The erosion control map was not included with the submittal.

SHOPS AT MCLAUGHLIN II

PRELIMINARY
GRADING
PLAN
9 OF 12

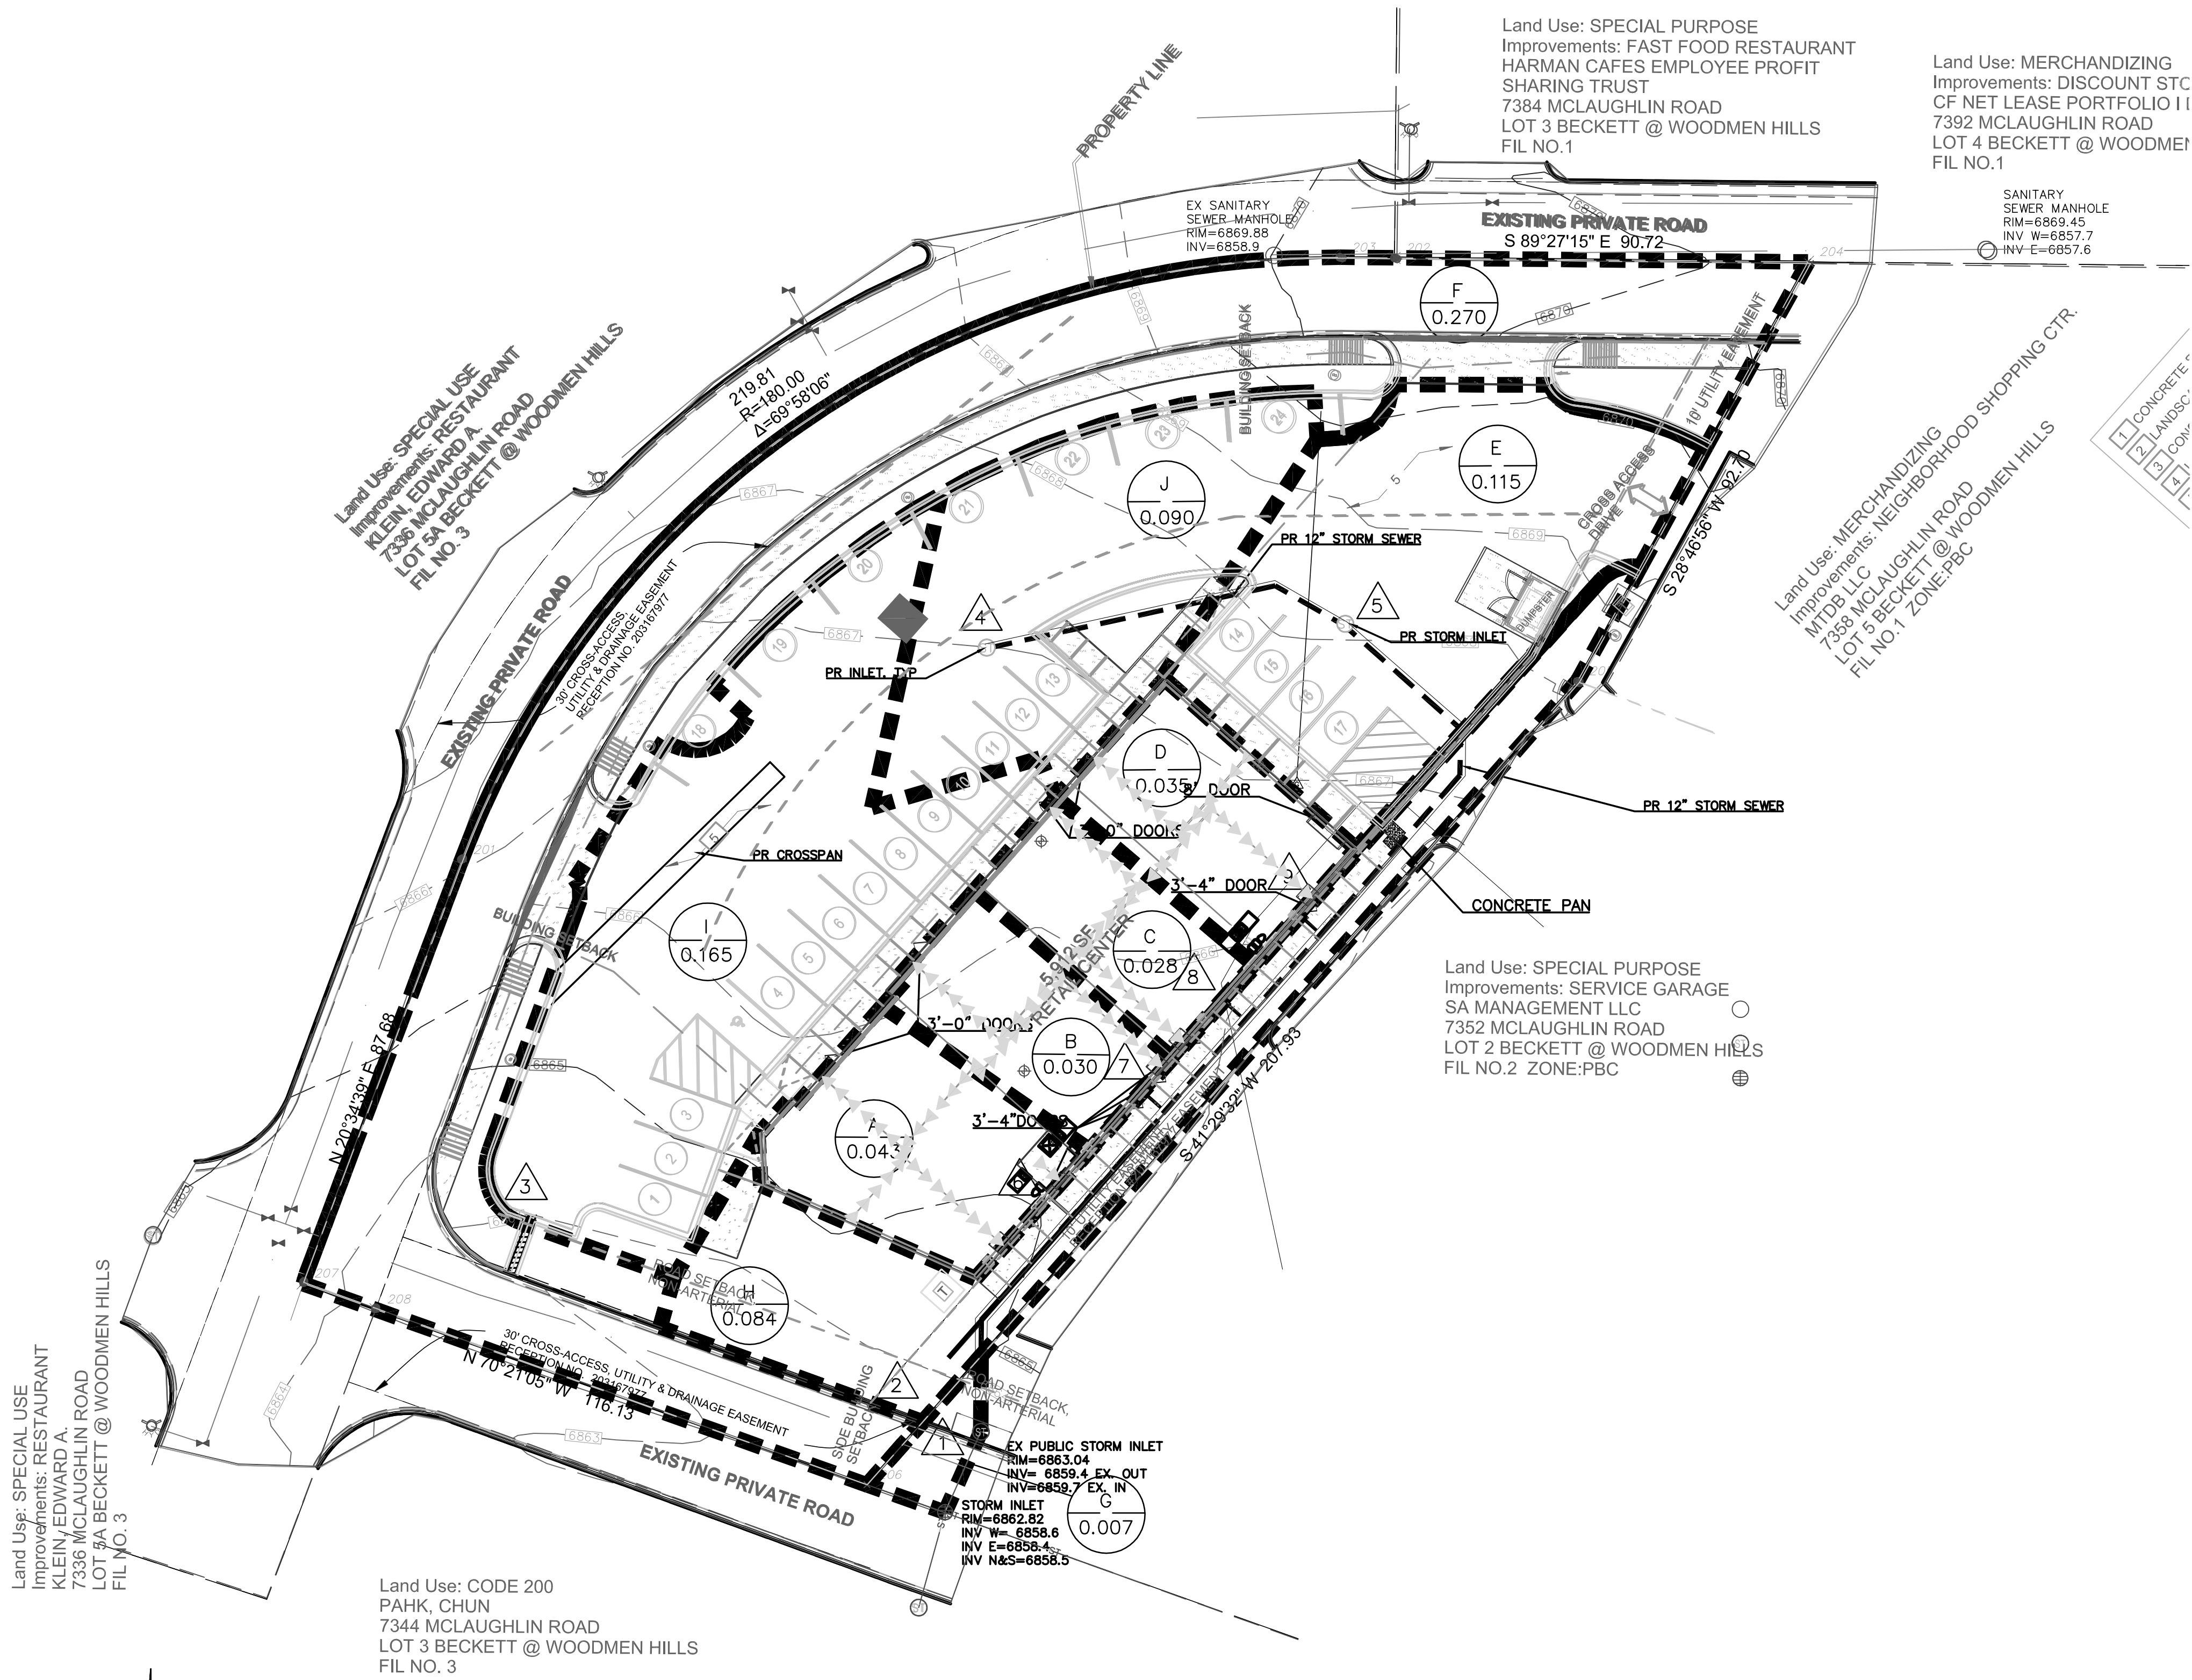
On the resubmittal. Submit a Grading and Erosion Control Plan (GEC) as a standalone plan set.

Revise label to Storm Inlet. Identify whether the existing inlet is public or private.

Identify the INV for both the incoming and outgoing pipes.
